RE: Revised EIS/BDAR Oxley Solar Farm, Armidale Regional Council (SSD-10346)

Enclosure: Attachment 1: Detailed BCD Comments – Revised EIS/BDAR – Oxley Solar Farm (SSD-10346)

Attachment 1: Detailed BCD Comments – Revised EIS/BDAR, Oxley Solar Farm (SSD – 10346)

Figure 1-14 Proposed onsite screen planting (Moir Landscapes, 2022).

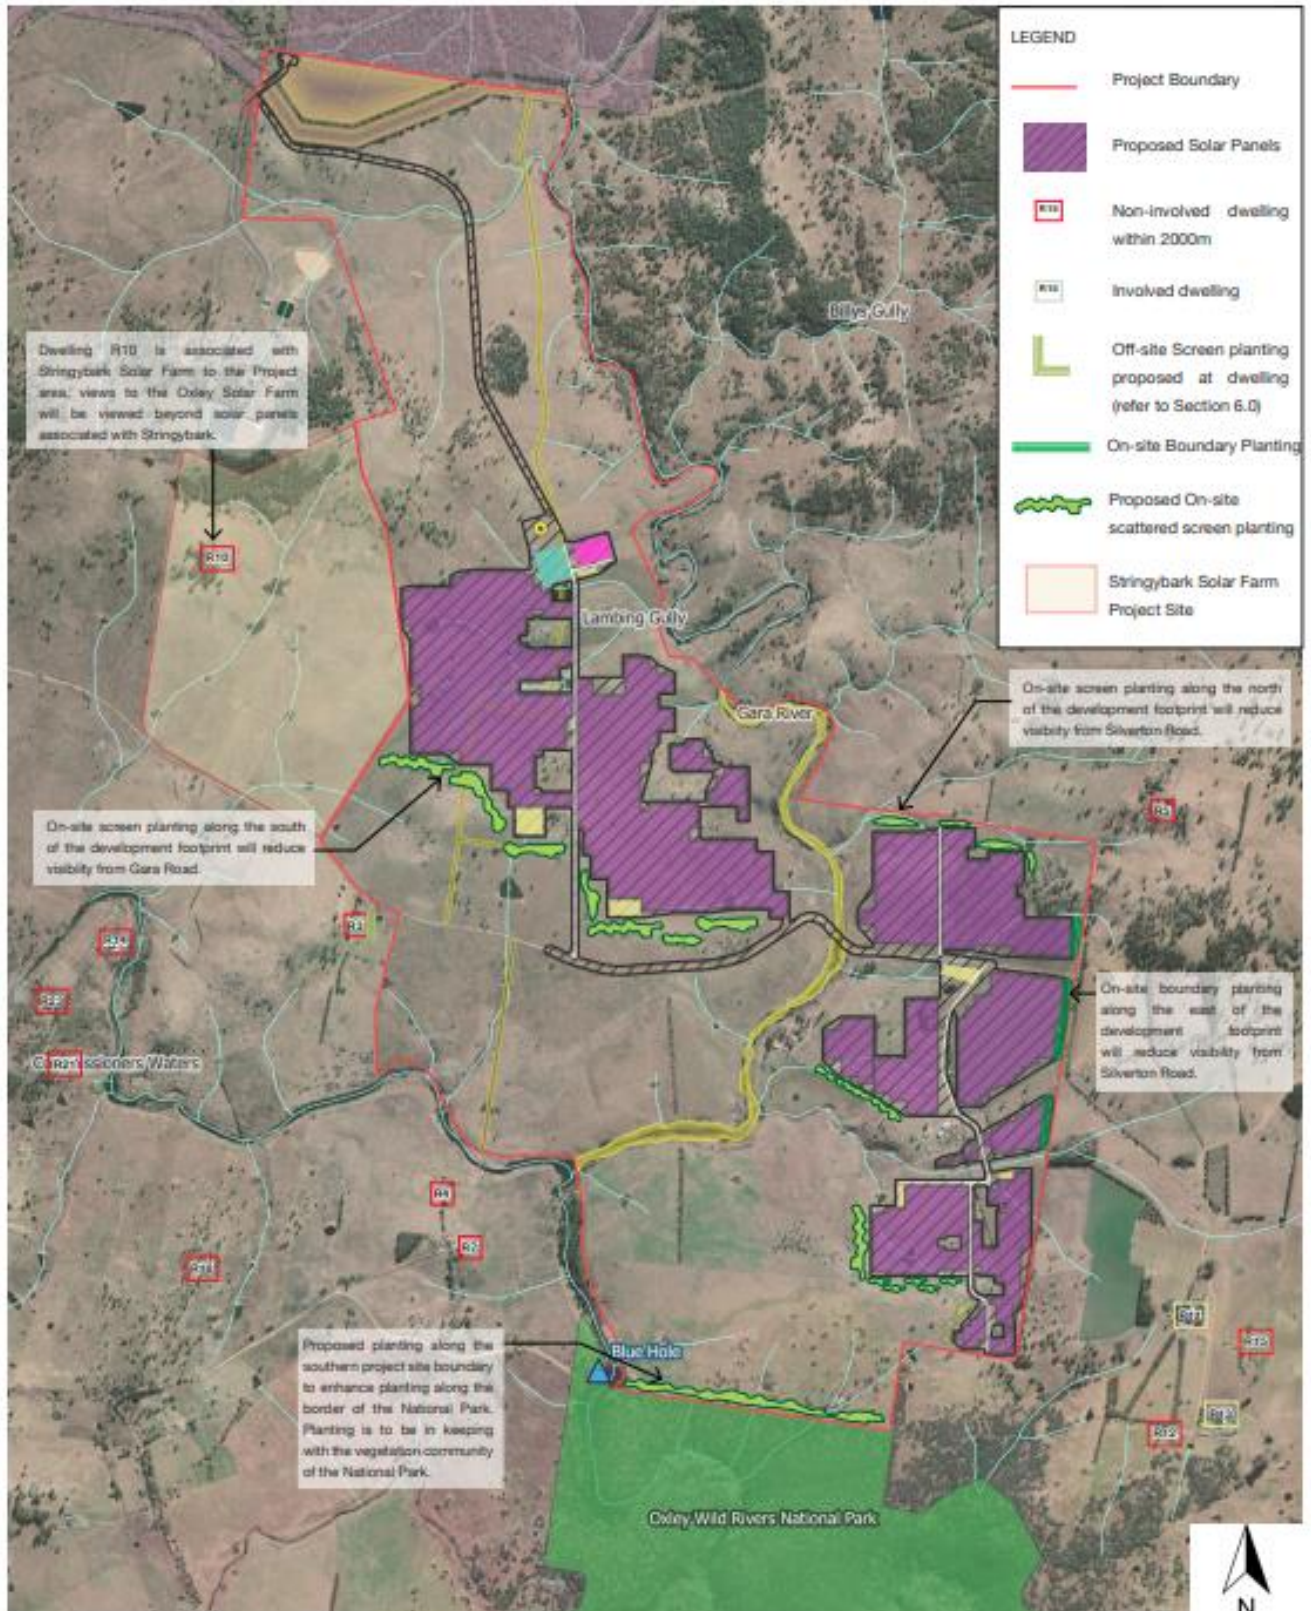
The provision of vegetative screening is supported by NPWS, however given mitigation of heritage impacts (as well as mitigation of glare, visual impacts etc.) relies heavily on vegetative screening, the following recommendations are made:

- a. It is recommended that, to reduce potential edge effects into park, the vegetative screening should comprise of endemic native species. The *Oxley Wild Rivers National Park, Oxley Wild Rivers State Conservation Area, Cunnawarra National Park and Georges Creek Nature Reserve Plan of Management* provides details of endemic native species occurring in the park.

- b. Section 1.3.9 of the Updated Project Description Report (NGH, October 2022) provides that all landscape works would be maintained regularly for a period of 24 months, however given landscape planting is proposed as a visual mitigation measure it is recommended landscaping be maintained until effective visual screening has been provided along the common boundary with park.

- c. Access to the fence line and bushfire risk of the locality does not appear to have been considered. Therefore, a setback should be provided between the vegetative screening and the existing fence line.

- a. Use endemic native species selected from the *Oxley Wild Rivers National Park, Oxley Wild Rivers State Conservation Area, Cunnawarra National Park and Georges Creek Nature Reserve Plan of Management*.

- b. Landscaping along the common boundary of the Oxley Wild Rivers National Park should be maintained for the entirety of the project.
 - c. A setback for bushfire management purposes and access between the vegetative screening and the existing National Park fence line is recommended.
